**KIRKLEES METROPOLITAN COUNCIL
INVESTMENT & REGENERATION SERVICE**

DELEGATED DECISION TO DETERMINE PLANNING APPLICATIONS

Reference No:	2022/62/90923/W
Site Address:	5, Pastures Way, Golcar, Huddersfield, HD7 4QG
Description:	Erection of two storey side extension
Recommending Officer:	Hubert Lam

Officer Report

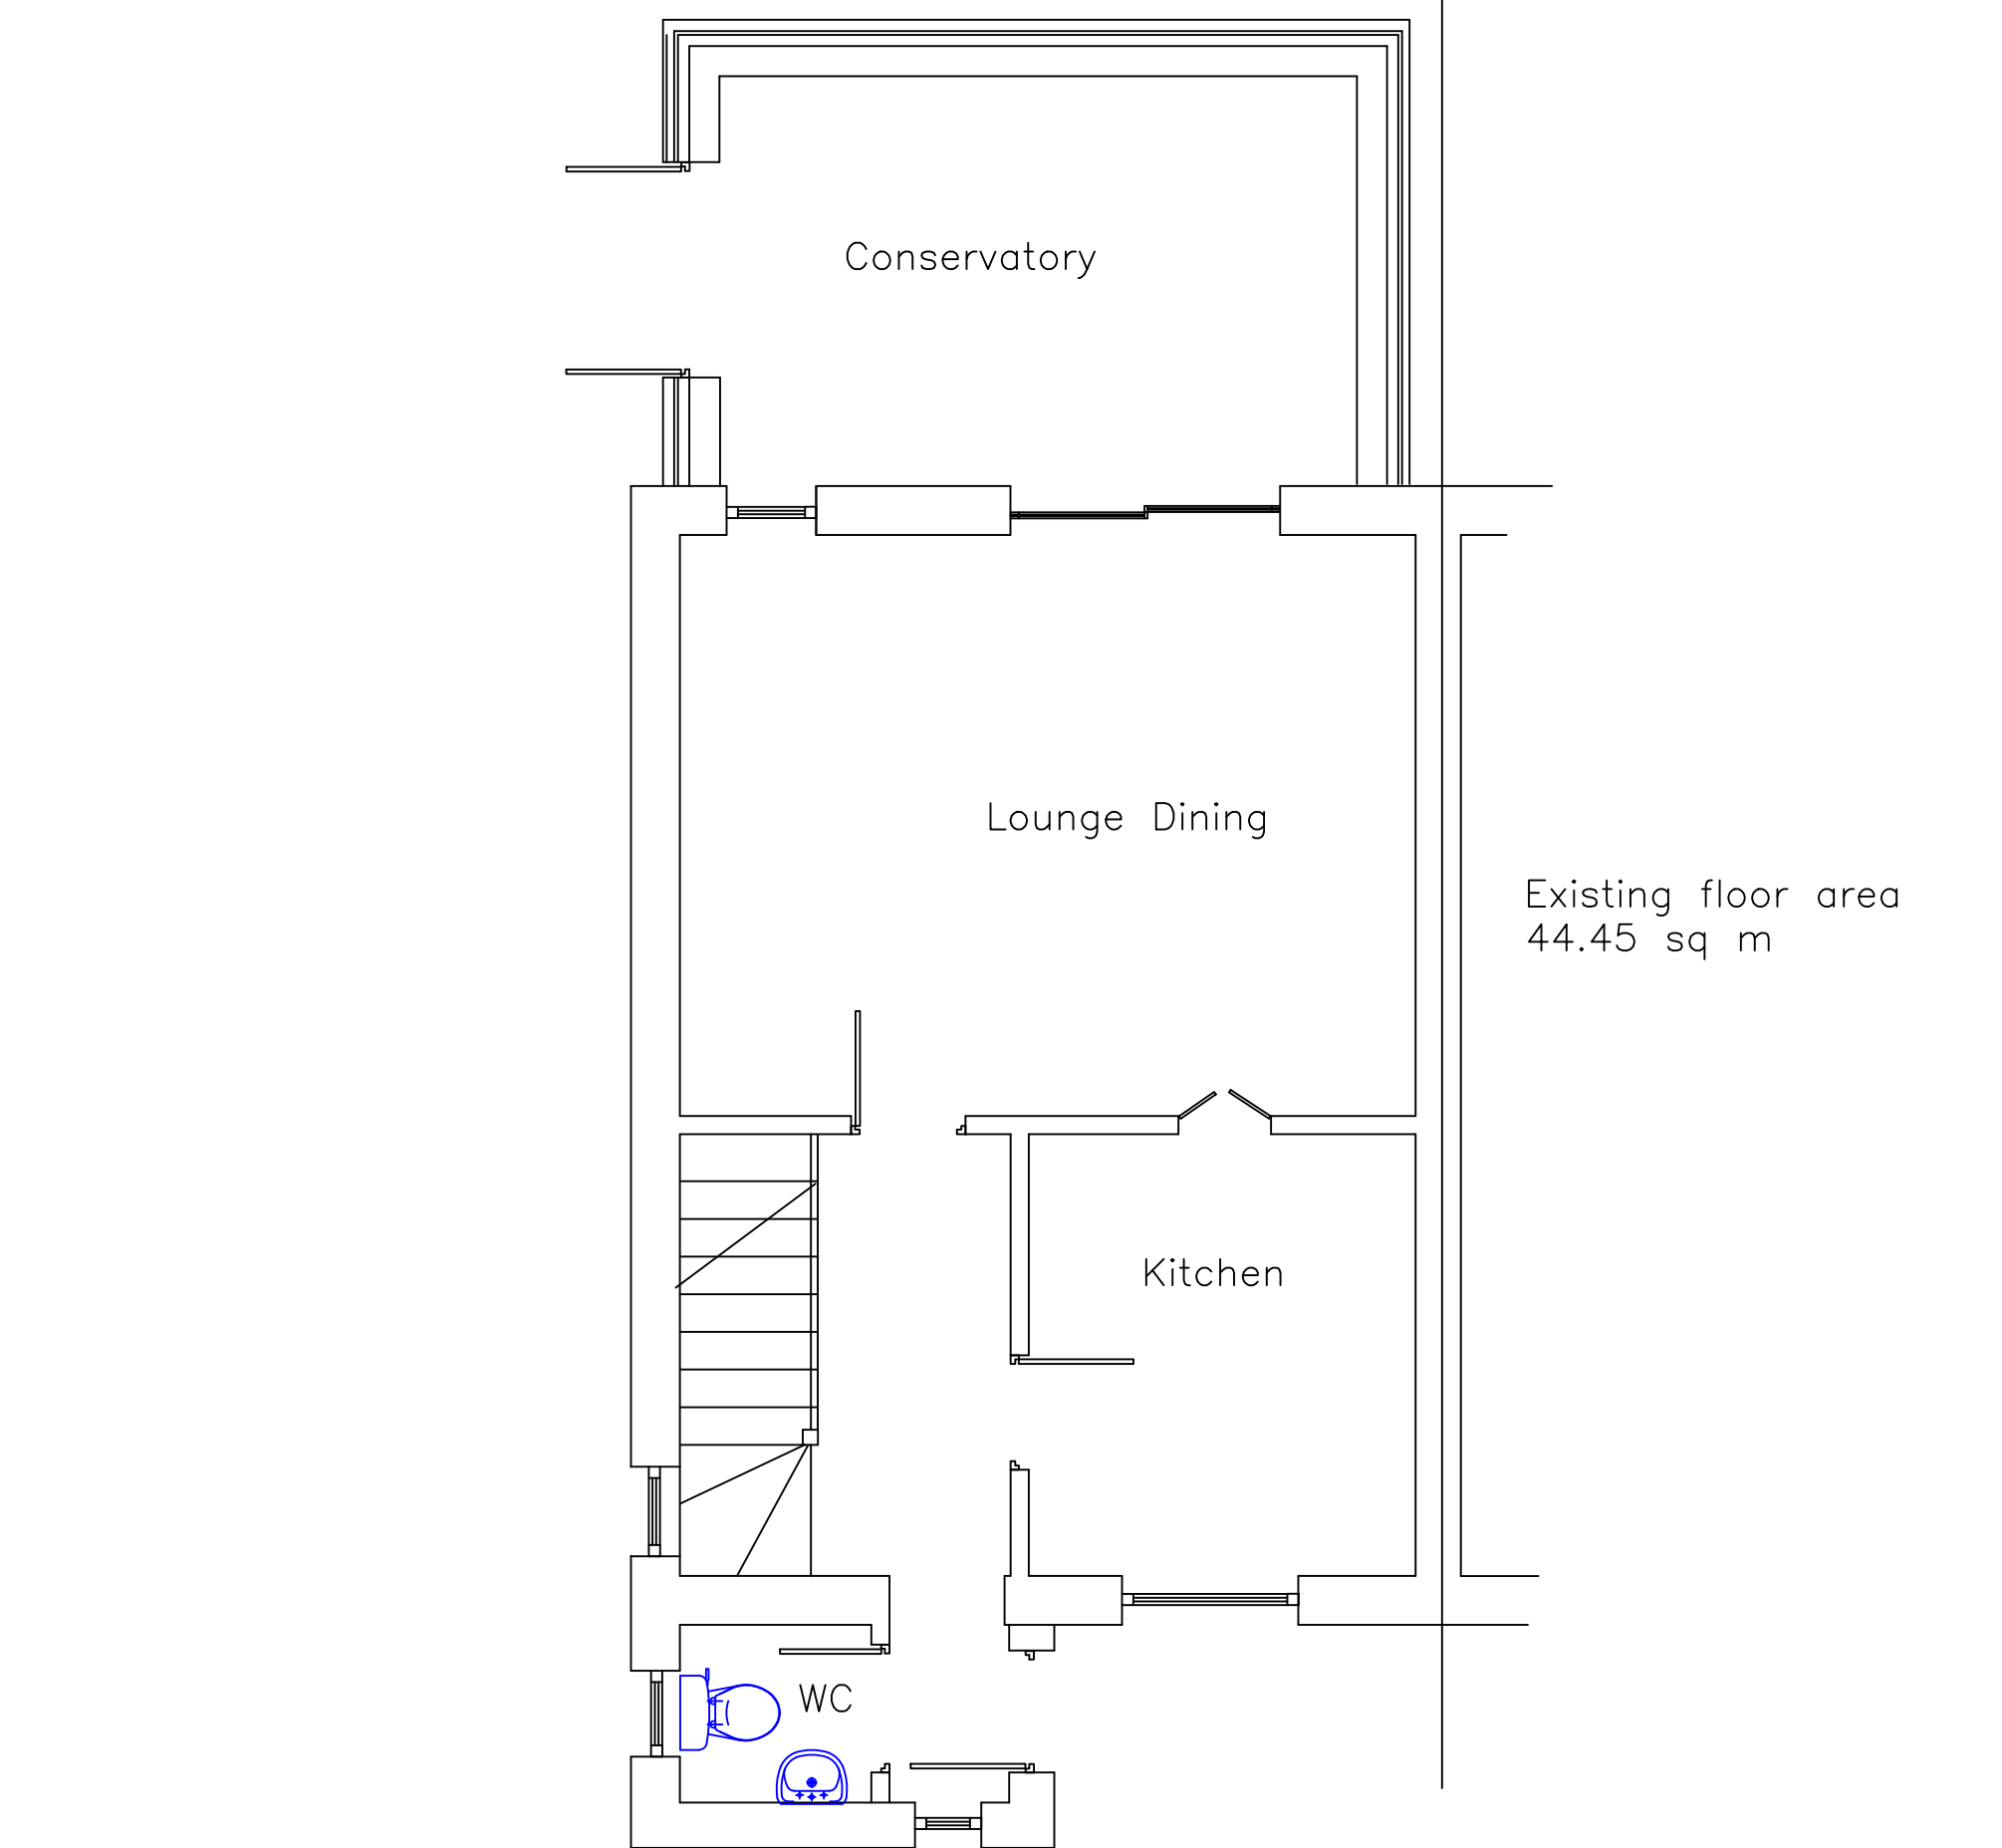
Further discussions and amendments were sought with the proposal being amended again set out in plans received 21 Jun 2022, consisting of the amended drawings NPPW/2022/02RevC, NPPW/2022/03RevC and NPPW/2022/04RevB.

These amended drawing reduced the size and scale of the proposal, including its projection from the side and also set the proposal back / down from the host property.

Further discussions have seen amended plans submitted which reduce the side projection of the proposal to 3.05m from the existing side (northwest) elevation of host property. The proposal, as amended, would maintain a separation of 5.9m from the curtilage boundary. The side to rear distance between the proposal and dwellings to the north east being 11m.

The proposed two-storey side extension, as amended, would project 3.05m from the side (northwest) elevation of the main house and would have a length of 7.05m aligning with the existing rear (northeast) elevation of the main house and set back from the existing principal (southwest) elevation by 500mm, with a dual-pitched roof section at a height of 7.8m to the ridge and 5.3m to the eaves.

The Scheme has been amended to reduce the side projection and therefore the overall width of the two-storey side extension to 3.05m, which, when compared with the initially proposed 3.85m projection from the existing side elevation, would ensure the rear to side relationship between the proposal and properties to the north would be 11m.

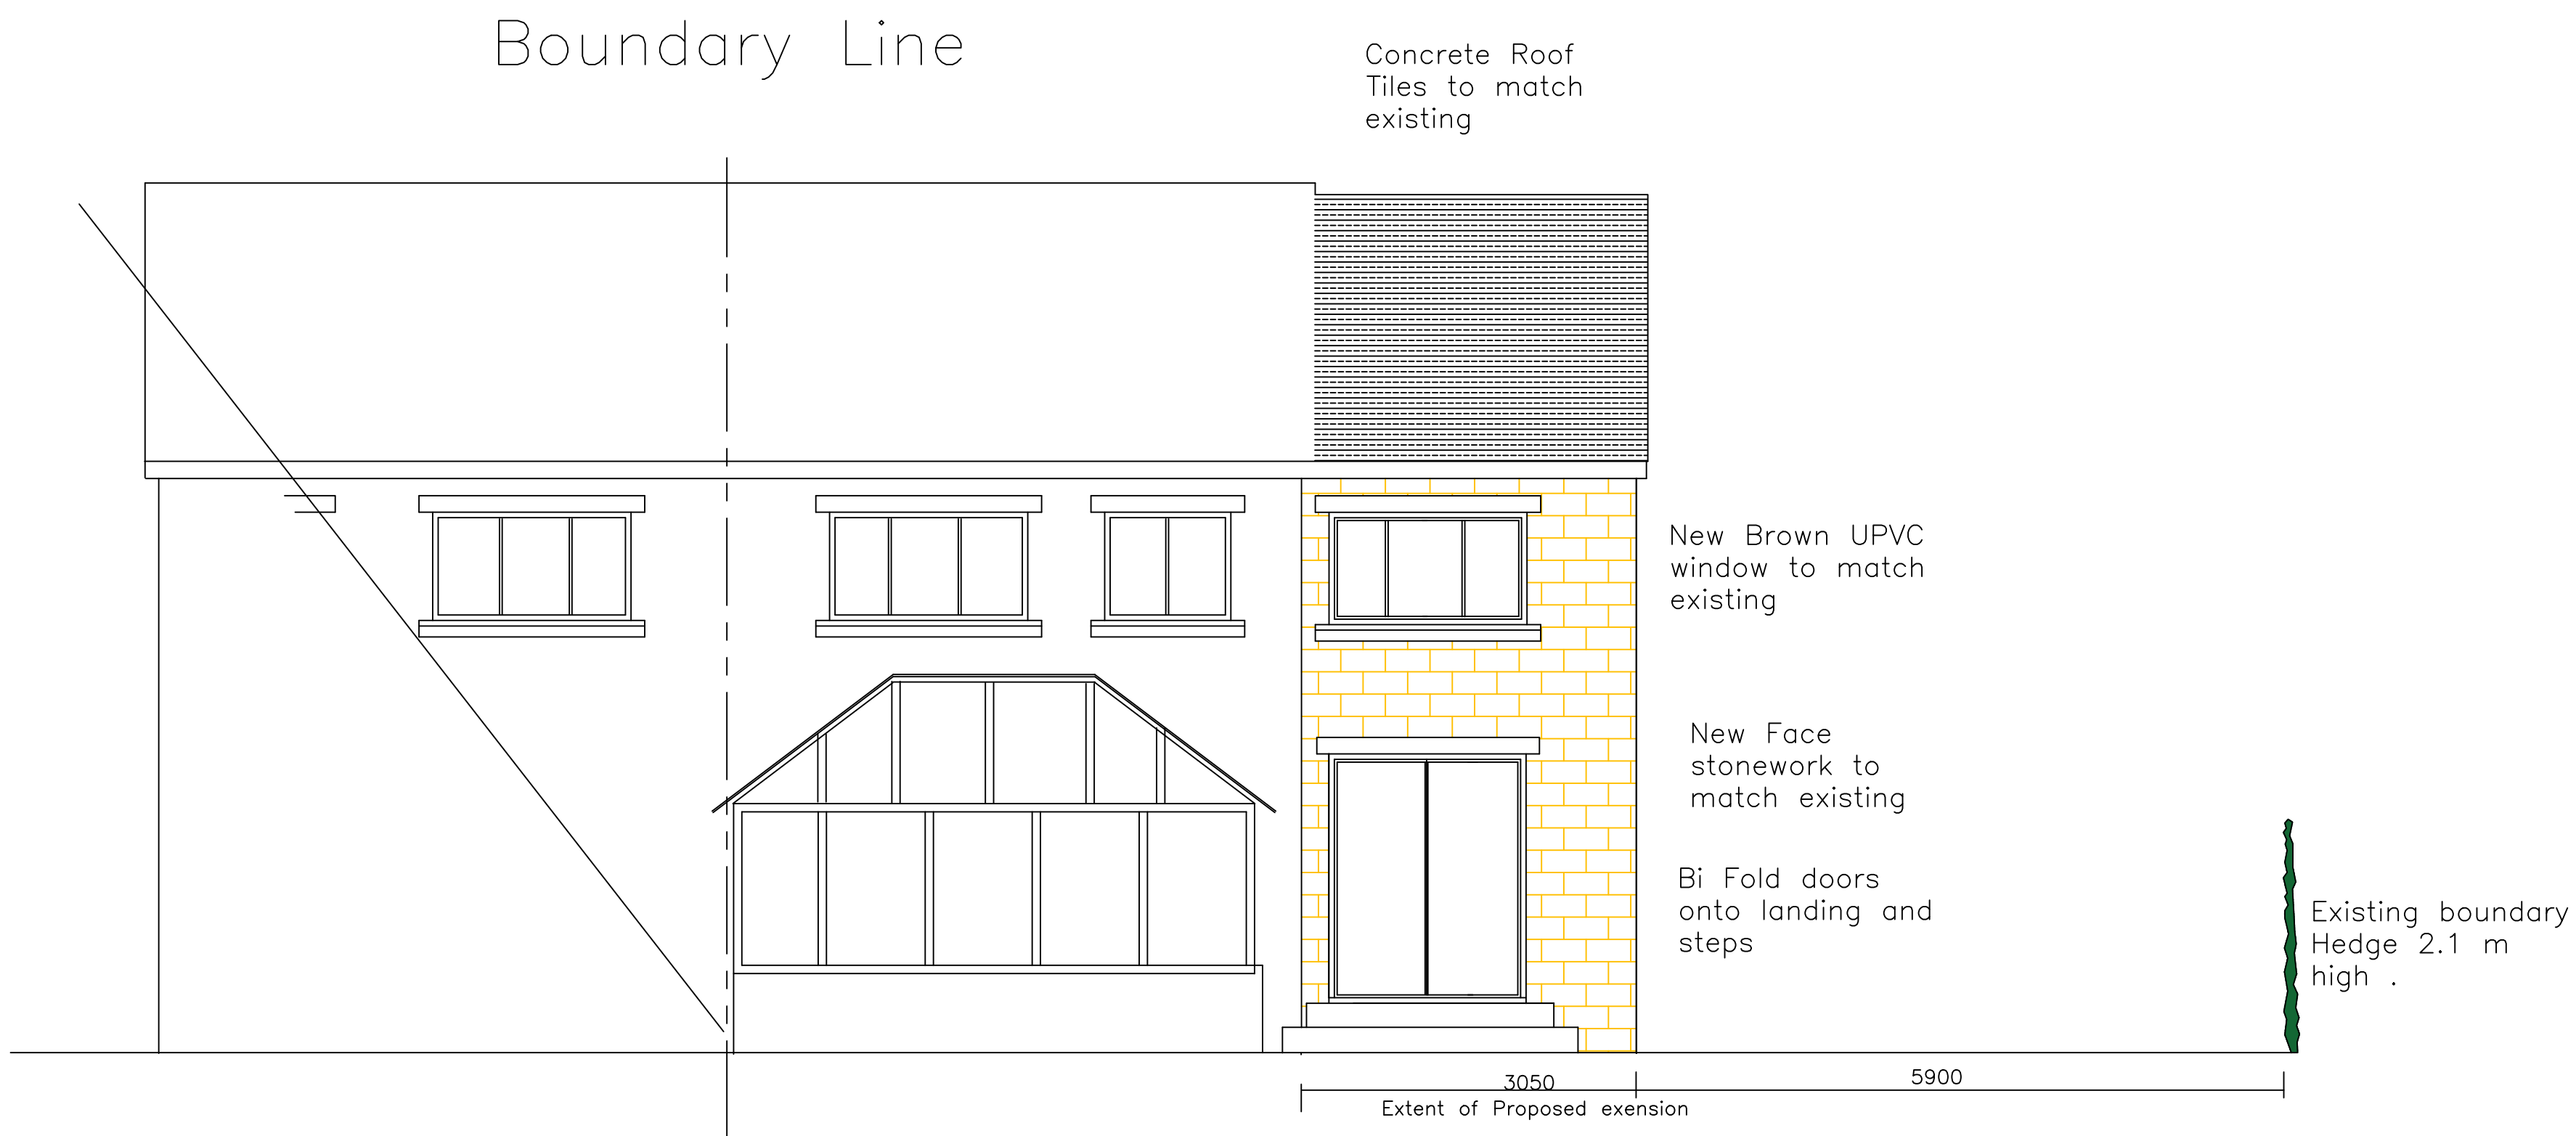
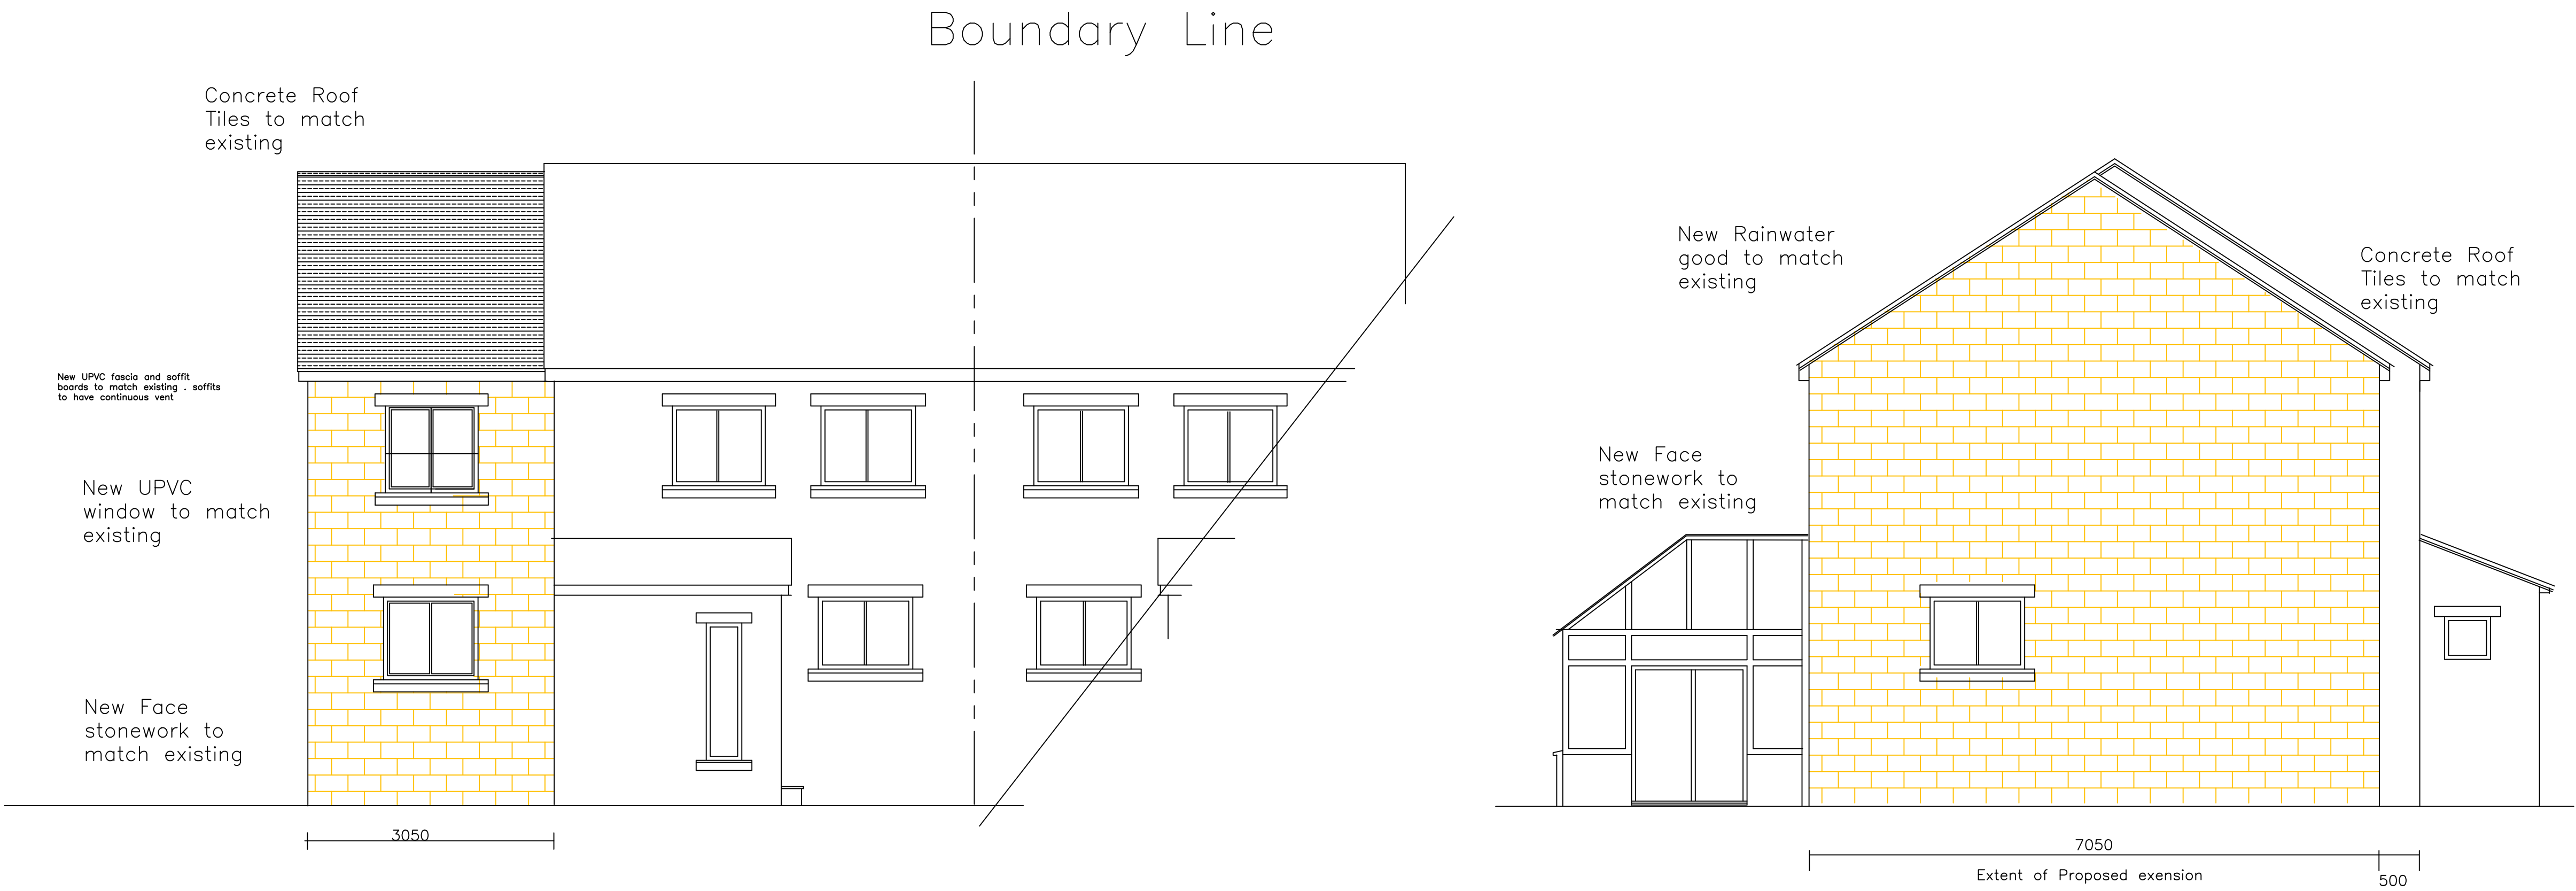
The two-storey side extension as initially proposed would project 3.85m from the existing side (northwest) elevation of the main house and would have a length of 7.55m, a dual-pitched roof section at a height of 7.6m to the ridge and 5.3m to the eaves, with a small gable insert feature on the first floor level intersecting the roof plane to the front elevation. The proposed materials

including the stonework for external walls, concrete roof tiles, and brown coloured inset windows and patio doors would match that on the existing house. The case officer raised concerns to the design, particularly the overall scope and amount, and scale, massing, layout, and orientation of the proposed two-storey extension with relation to that of the existing main house, the proposed front roof insert / gable feature that would appear incongruent with the architectural style and features on the existing house, and the outlook and appearance as seen from neighbouring properties and the public domain.

The proposal has been amended with the roof height and front elevation being set down / back from that of the host property.

One ground floor opening is proposed to the side elevation, which serves a kitchen. Openings serving a kitchen, study, bedroom and en suite are proposed to the front and rear elevations.

As such, subject to the condition securing external materials and appearance matching that of the existing main house, the proposal, as amended 21 June 2022, is considered to be proportionate and subservient when considered with relation to the existing main house.

be created in the north western (side) elevation of the two storey extension to side hereby approved.
